SITE NAME: OVERHILLS ELEM. - CLASSROOM ADDITION
PROJECT: EMERGENCY RESPONDER COMMUNICATION ENHANCEMENT SYSTEM (ERCES)
BUILDING ADDRESS: 2626 RAY ROAD, SPRING LAKE, NC 28390

Reviewed for Fire Code Compliance
 Harnett County Leslie Jackson
 01/23/2024 2:09:26 PM

Revision History		
Rev	Date	Author
01	11/18/2023	JDO
SHDP DRAWINGS 100%		
Project name		
OVERHILLS ELEMENTARY - CLASSROOM ADDITION		
Address		
2626 RAY ROAD SPRING LAKE NC 28390		
Designer name		
JDO		
R0.00		
COVER SHEET		
11/18/2023

Revision History	Author
Rev #	Date
1	11/18/2023
SHCP DRAWINGS 100%	
Project name	
OVERHILLS ELEMENTARY - CLASSROOM ADDITION	
Address	
2628 RAY ROAD SPRING LAKE NC 28390	
Designer name	
JD	
R8.01	
ONE LINE DIAGRAM	
11/18/2023

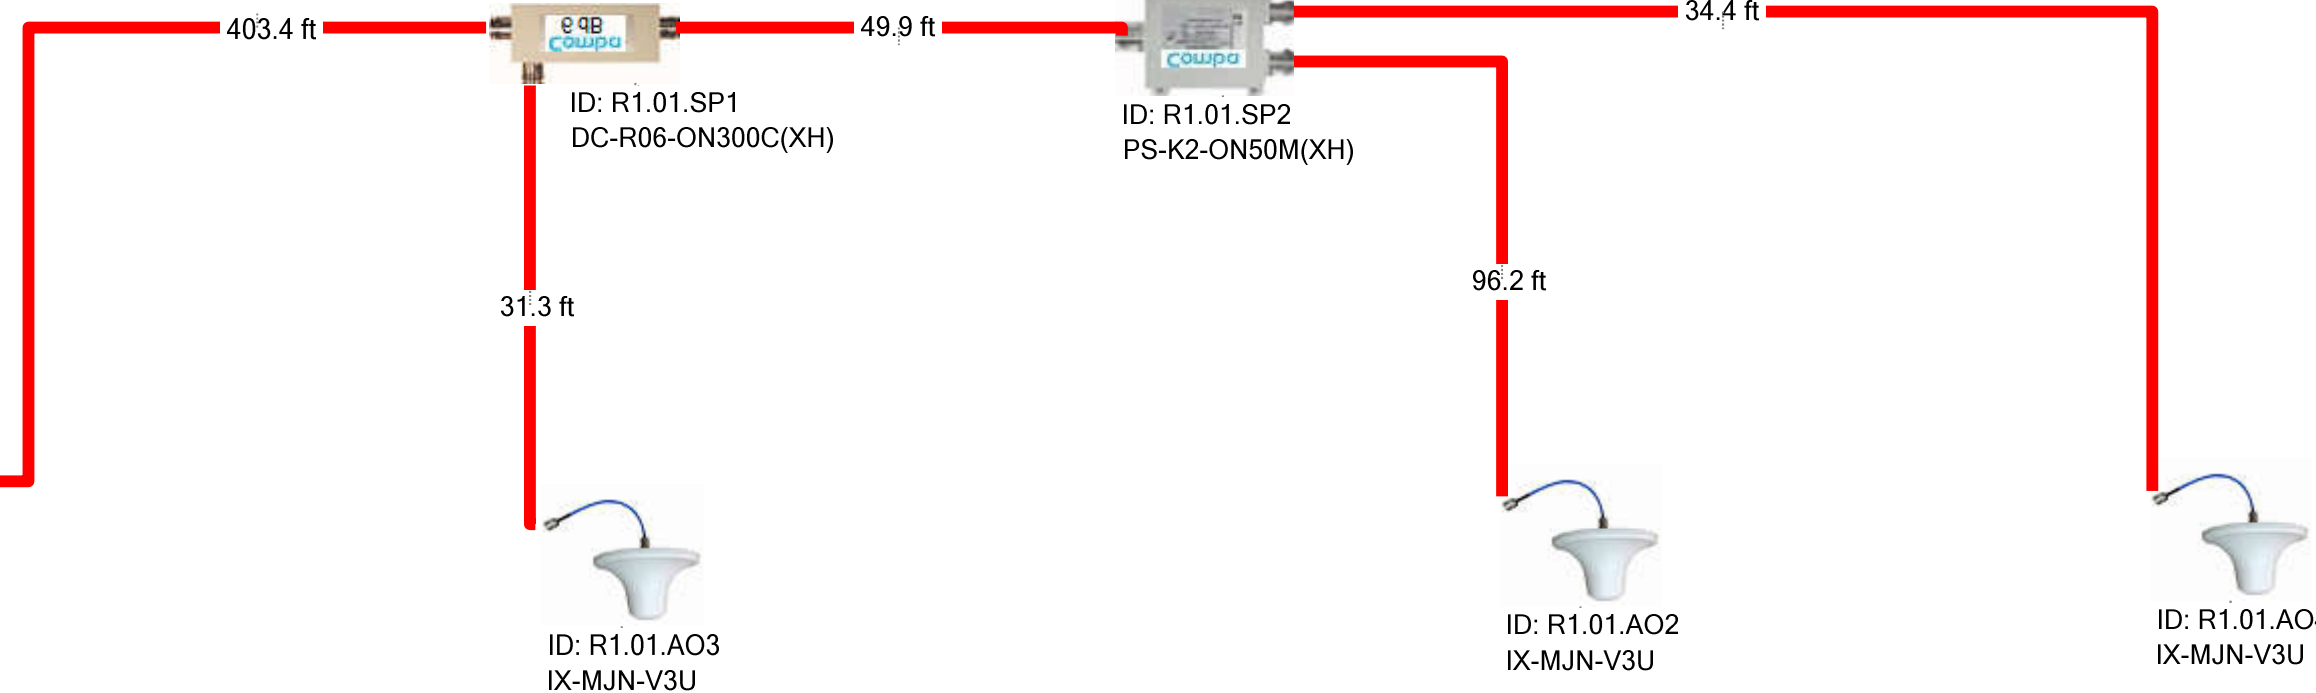
Site name is incorrect

Wrong address
